# CITY OF ALBUQUERQUE

August 28, 2018

**RE: Adagio Apartments  
Tr A, Cantata at the Trails Unit 2  
Conceptual Grading Plan Stamp Date: 8/16//19  
Drainage Report Stamp Date: 8/16/19  
Hydrology File: C09D014**

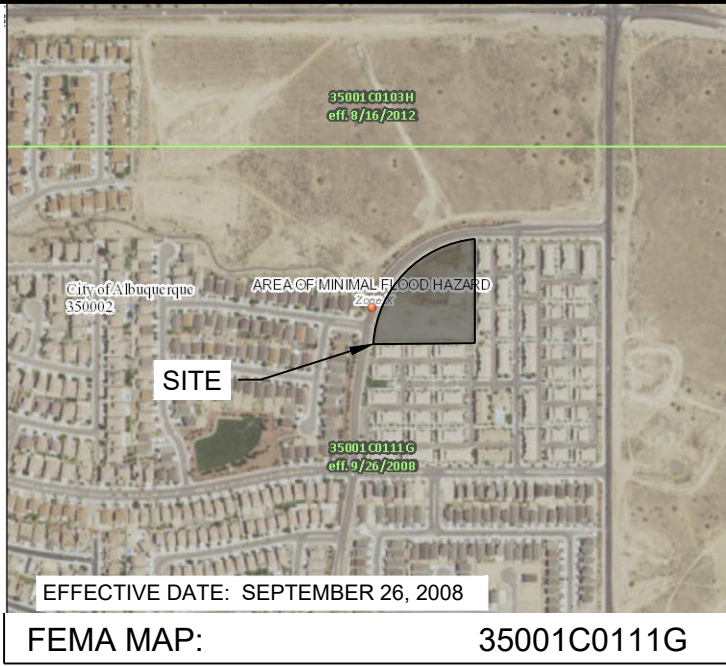
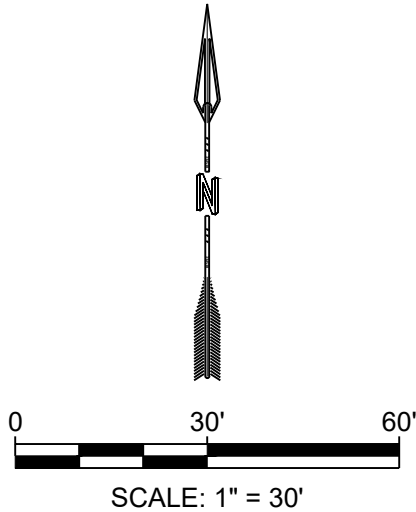
1. Remove all "Conceptual" markings.
2. Required SWQV needs to be calculated for the impervious area only. It looks like you multiplied .34/12" by the entire basin areas.

3. Payment in Lieu (Amount =  $1,827\text{CF} \times \$8/\text{CF} = \$14,613$ , per sheet C-102- Basin1.2) of onsite management of the SWQV must be made. Take three copies of the treasury deposit slip to the Treasury and then include one copy of the paid deposit slip when resubmitting.

6. Please show and label the pond(s) and include a label on each with the SWQV and elevation, the 100-year volume and elevation, the peak 100 year inflow and outflow, the spillway crest elevation, and the spillway flow depth.
